REVIEW OF DOCUMENTS RELATING TO AIR QUALITY

DRAYTON SOUTH COAL PROJECT

PLANNING ASSESSMENT COMMISSION

DATE OF ISSUE: 12 OCTOBER 2015

FIGURE 7 INDICATIVE DRAYTON SOUTH AIR QUALITY CONTOURS - ANNUAL AVERAGE PM₁₀ PROJECT

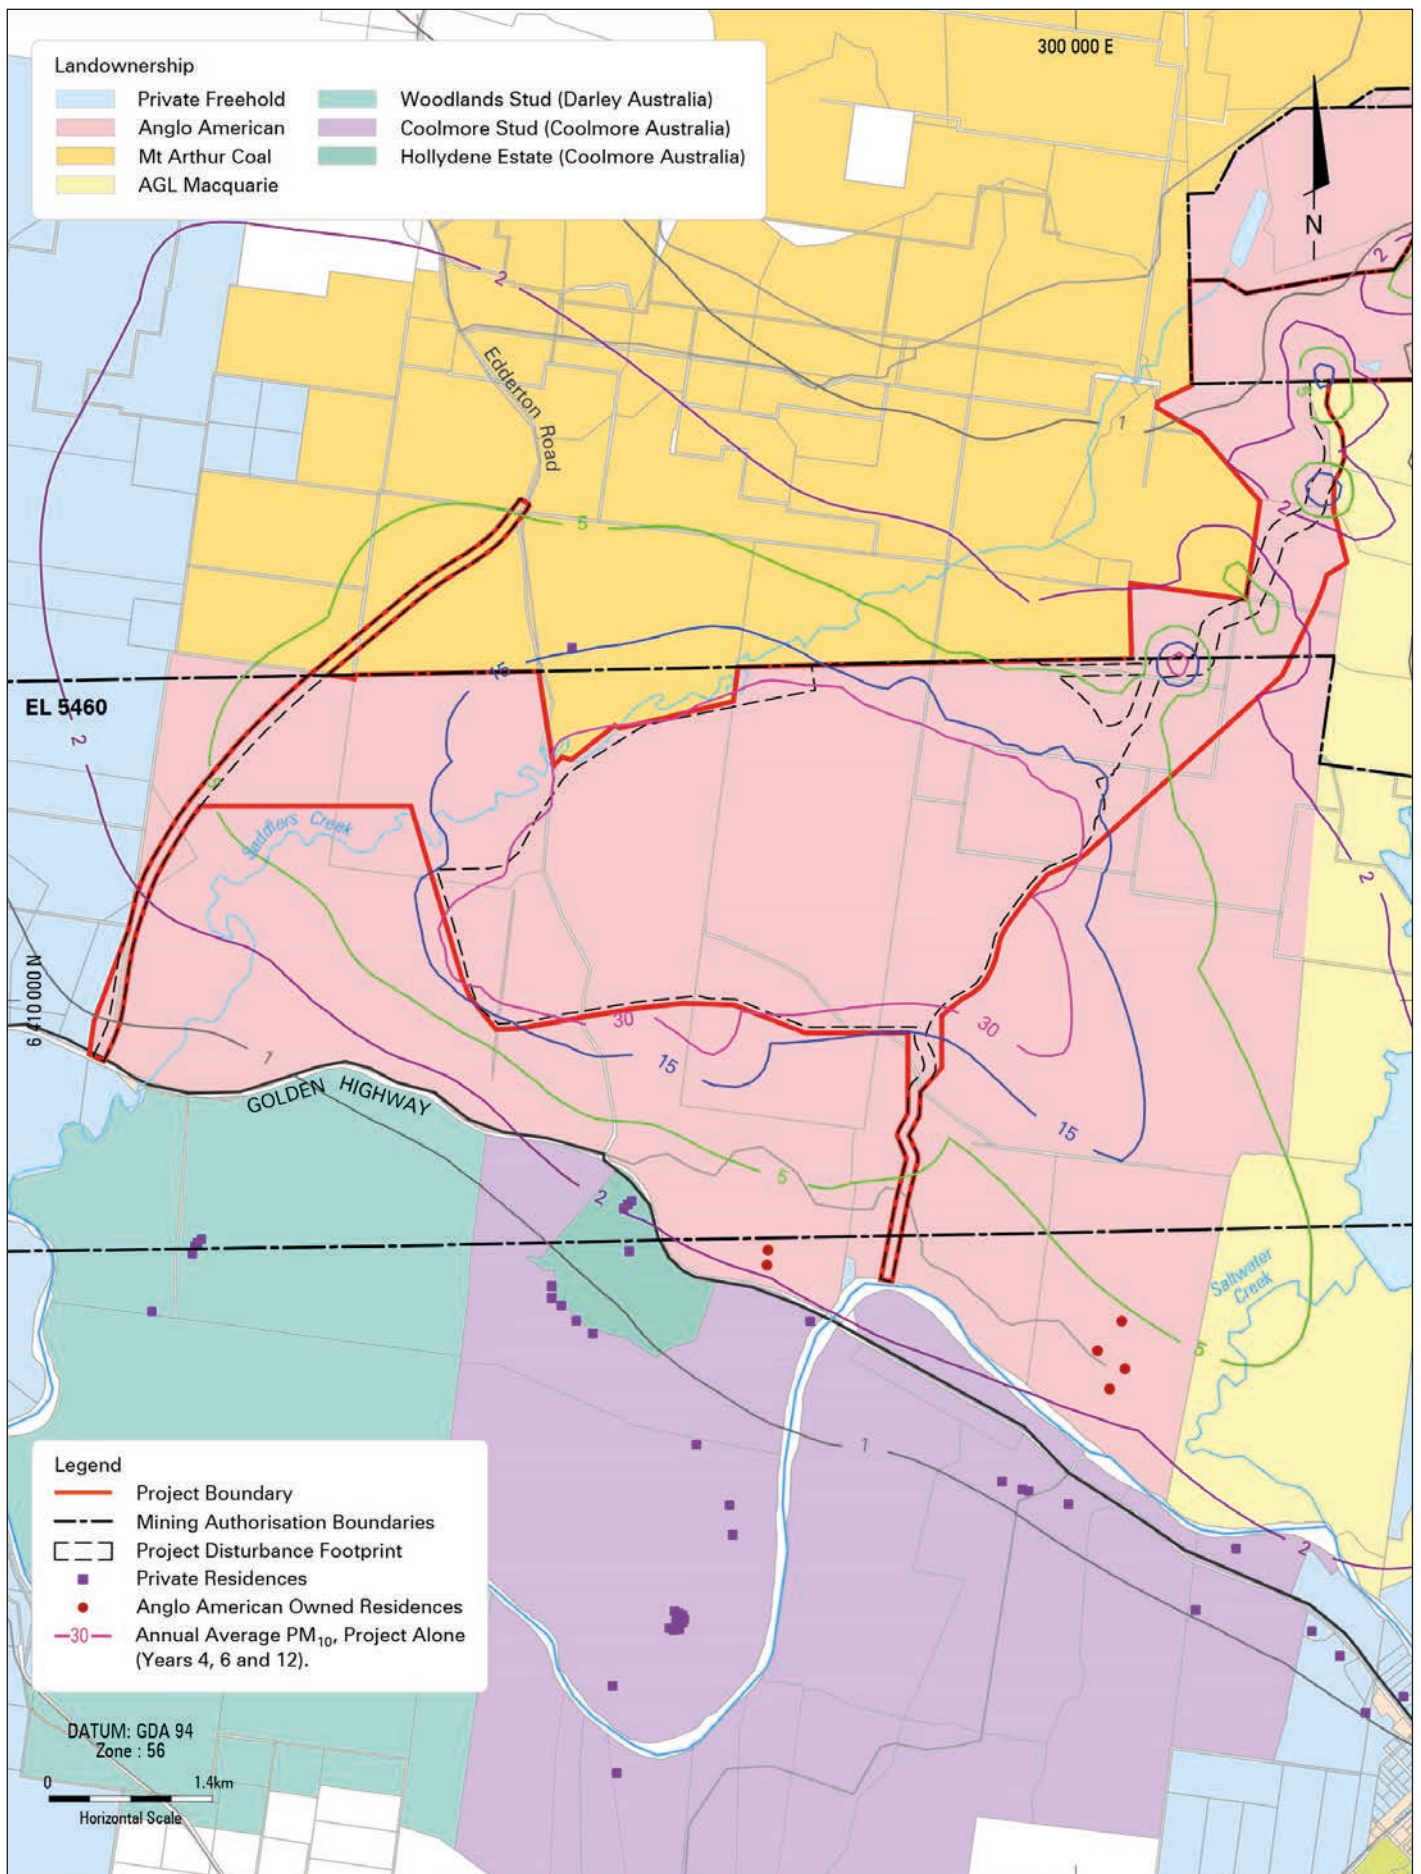
- Based on Anglo American's data under a worst case scenario the "project alone" impacts on air quality will exceed the relevant air quality limits from Year 4. When this project impact is added to background levels the cumulative impacts will substantially exceed the impact assessment criterion.

- Project Only predictions will exceed Impact Assessment Criteria when added to the Background air quality. Furthermore, these predictions have a potential to be gross underestimates if any of the nominated dust controls fail to meet the nominated 80% efficiencies.
